KITTITAS COUNTY

MEMORANDUM

TO: Community Development Services
FROM: Public Works Plan Review Team
DATE: August 26, 2021
SUBJECT: SE-18-00008 Sparks Park

SEPA Application Comments

SPARKS ROAD  
NATHAN WEIS  
GRADING AND DRAINAGE PLAN

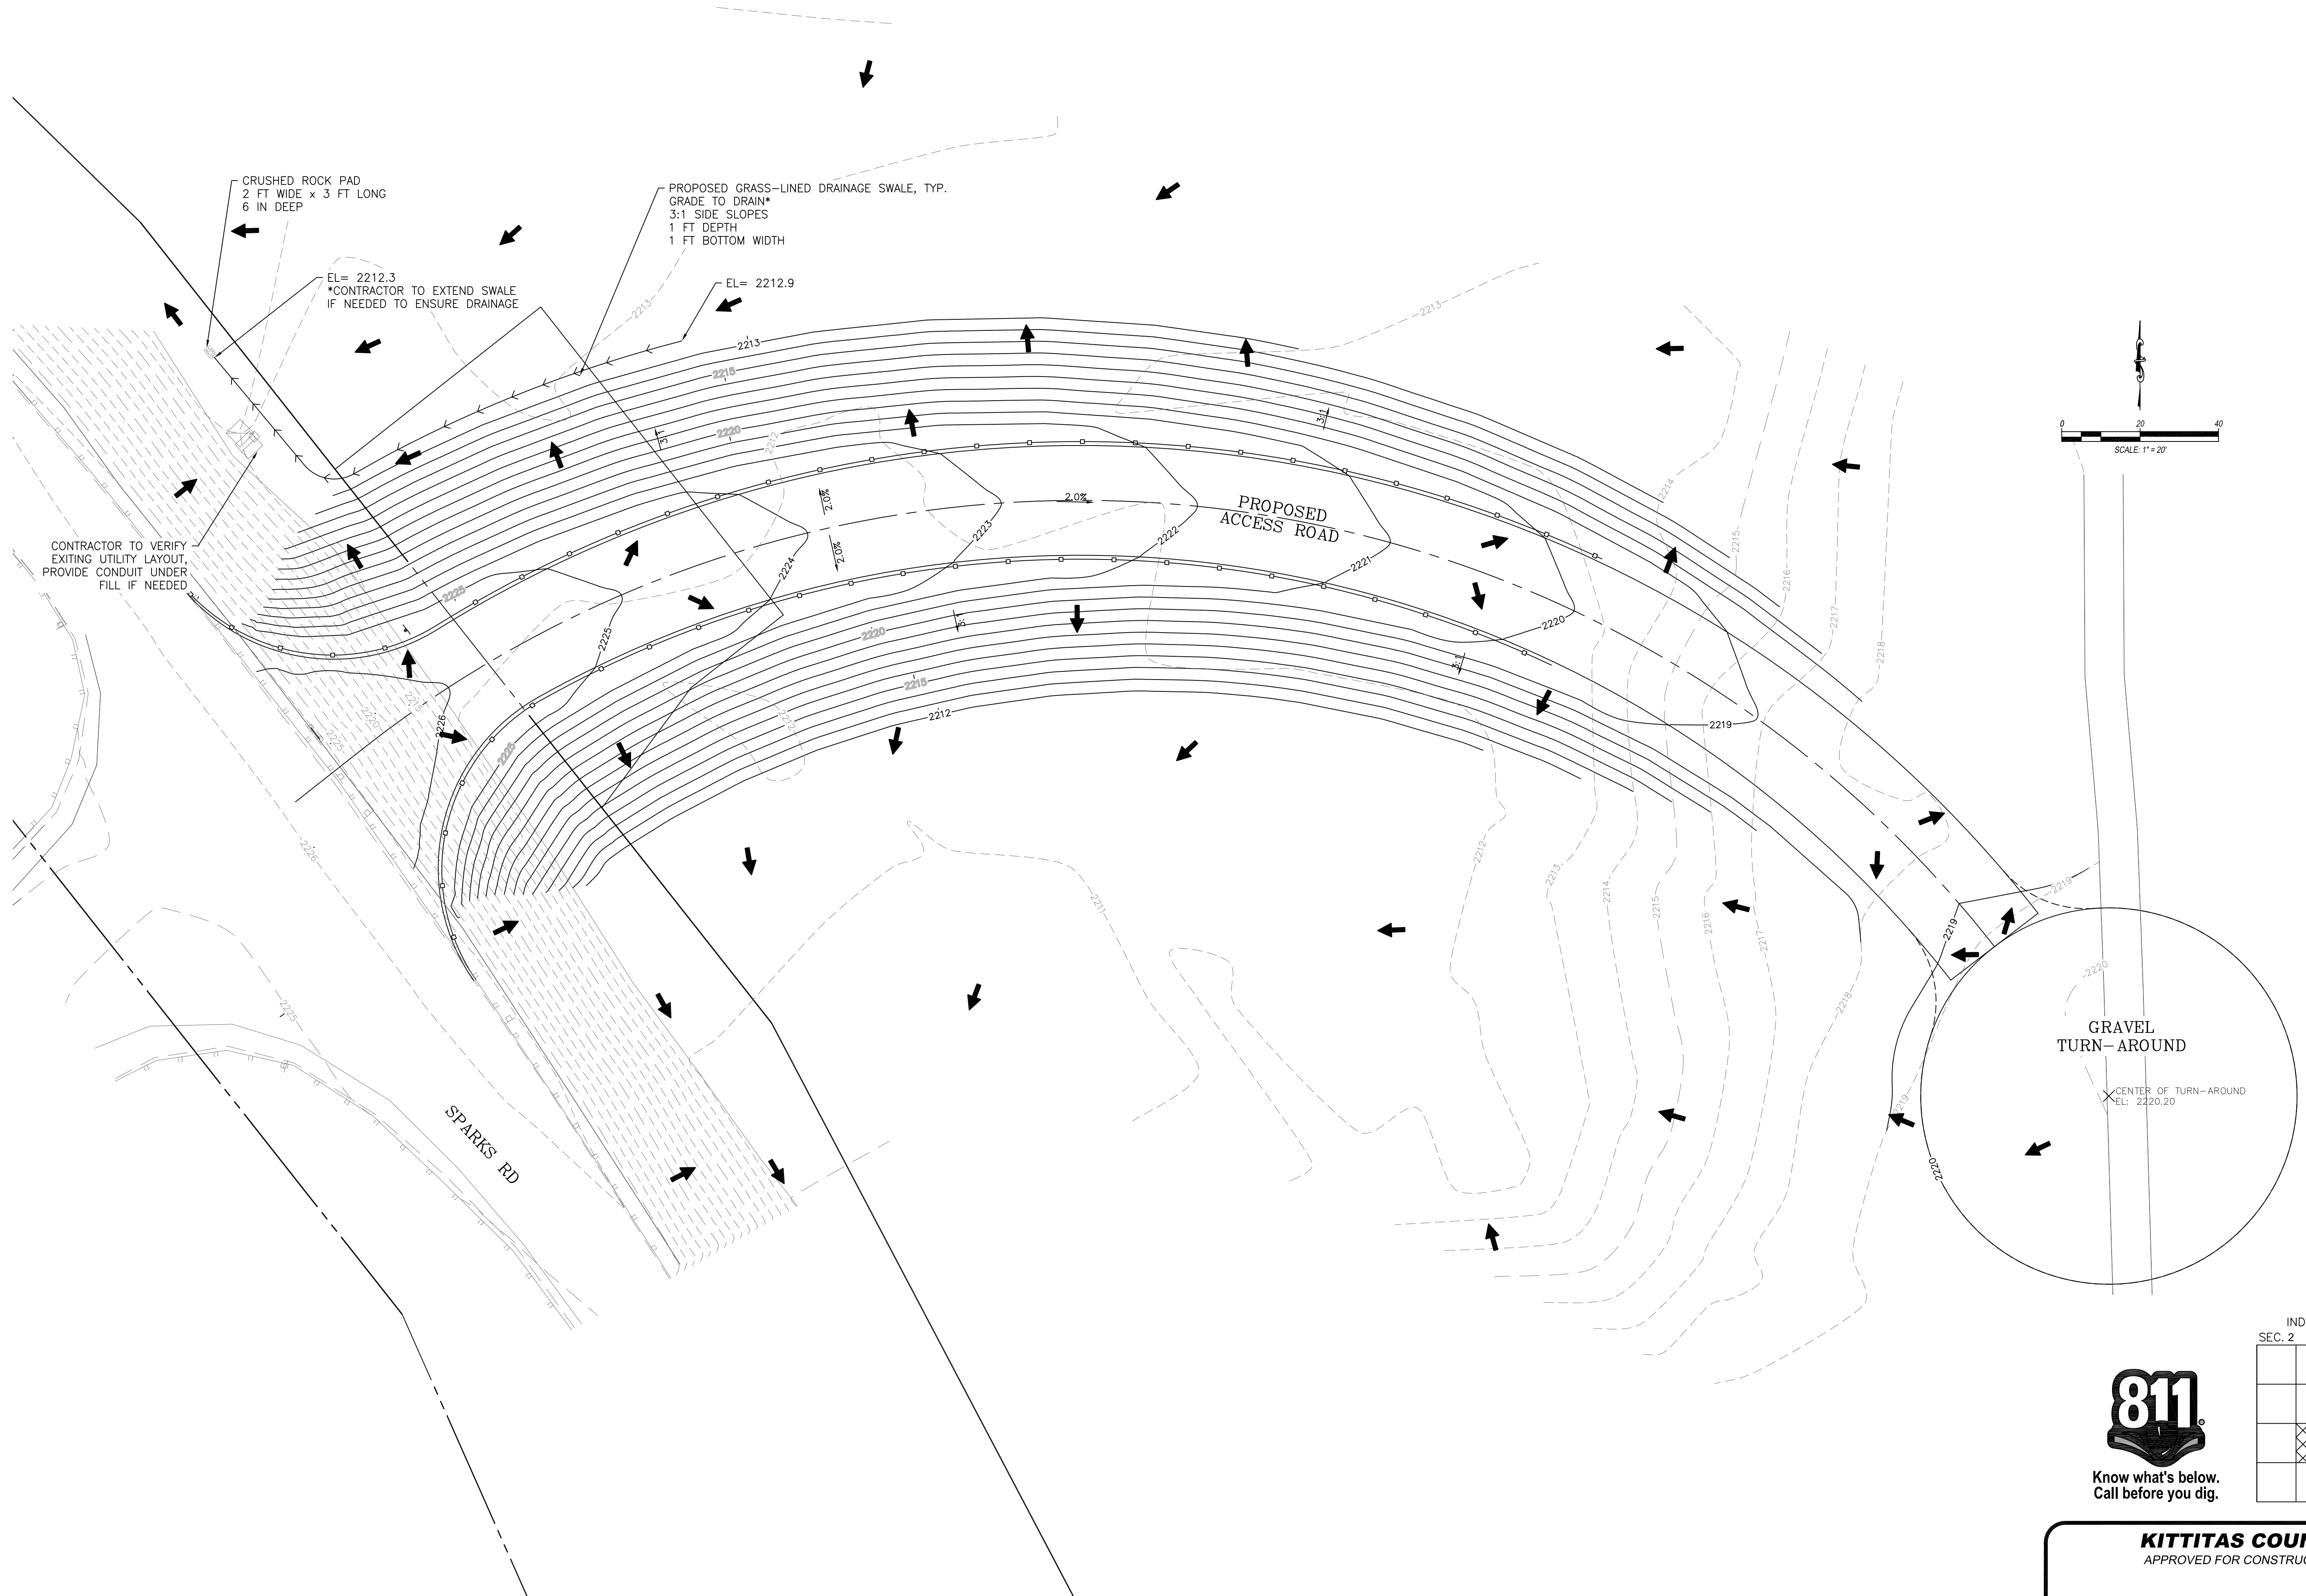
- Grading over 500 cubic yards of material requires engineered grading and stormwater plans. See Kittitas County Code Chapter 14.05. No grading is to occur until the application is reviewed and issued. Grading permit GP-21-00004 is currently under review for the subject parcel.

- Stormwater submittal is to comply with the Stormwater Management Manual for Eastern Washington (SWMMEW).
- Please be aware that a traffic impact analysis (TIA) may be required at the time the intended use of this access is determined. A TIA is required for projects generating more than 9 vehicle trips per peak hour. Mitigation of any impacts identified in the TIA are required.

**SPARKS ROAD**  
 NATHAN WEIS  
 ROAD PLAN AND PROFILE

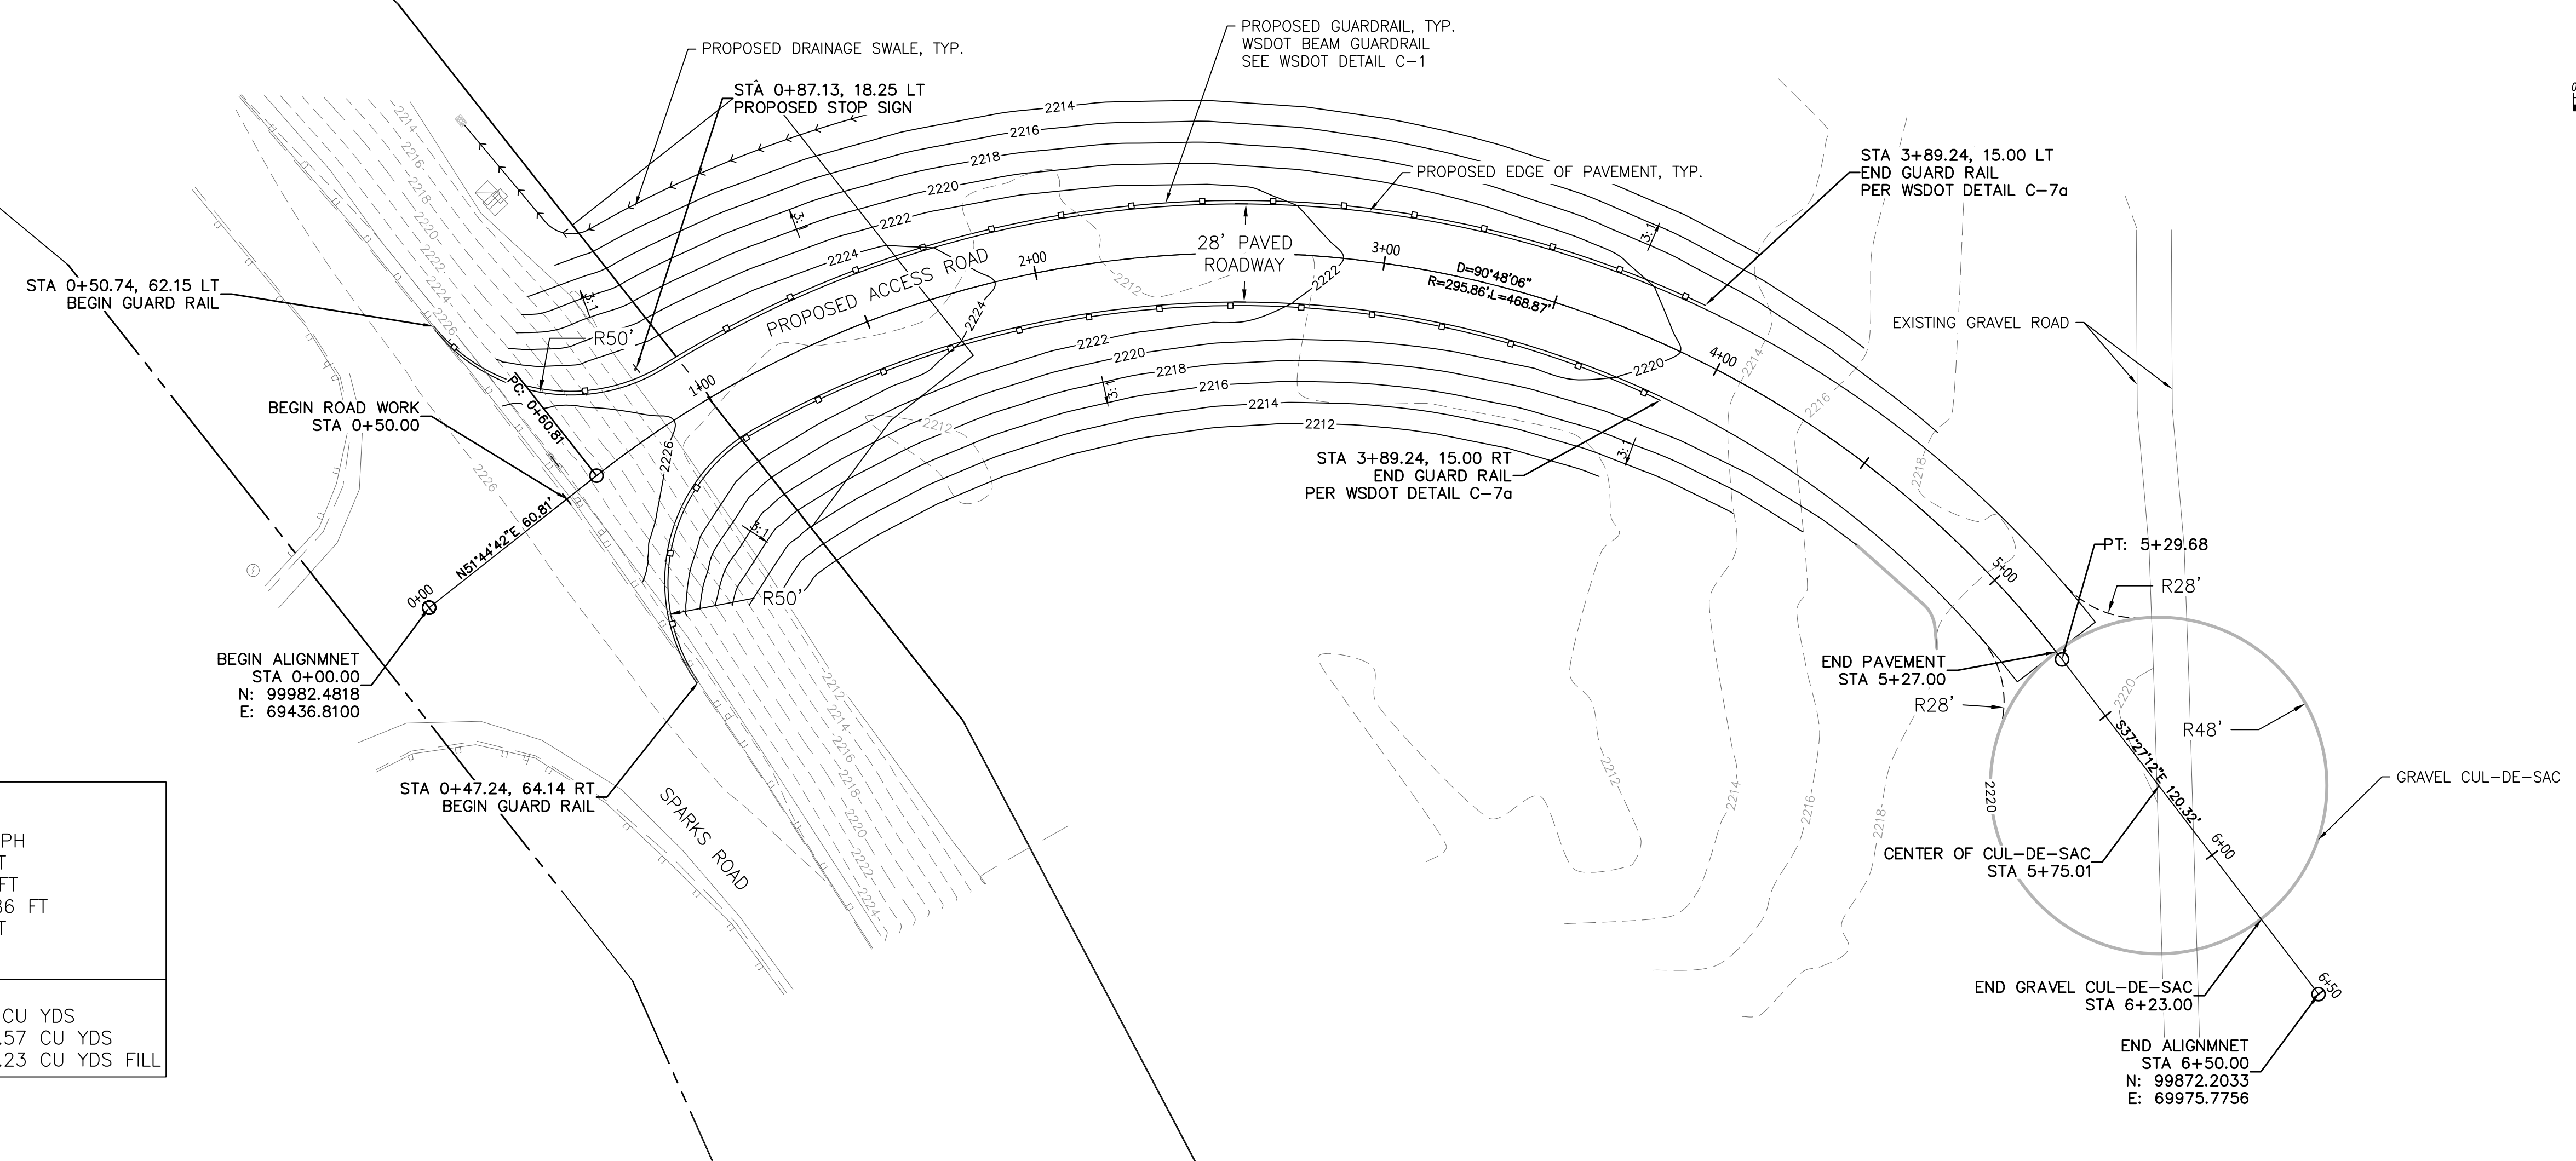
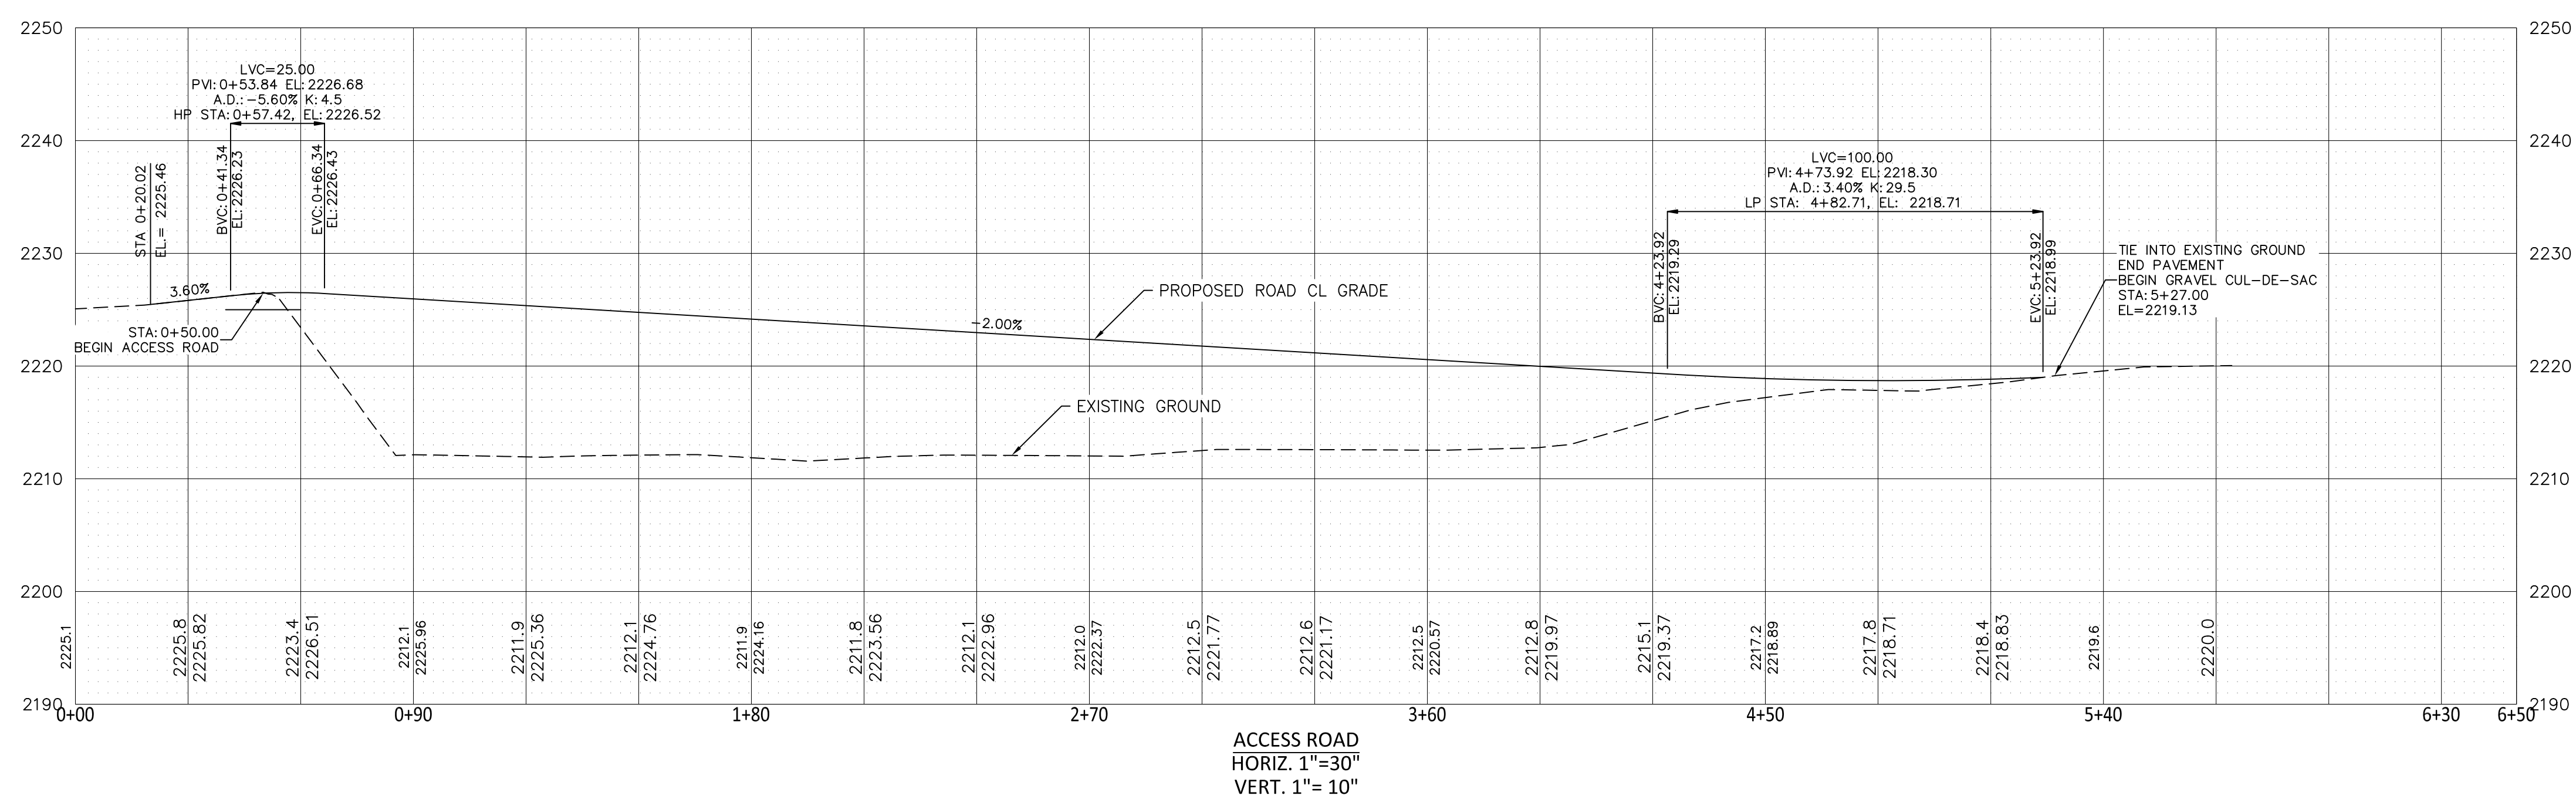
- The proposed access shall meet or exceed current Kittitas County Road and Bridge Standards.
- An approved access permit shall be required from the Kittitas County Department of Public Works prior to creating any new access. Access permit AC-21-00020 is currently under review for the subject parcel.
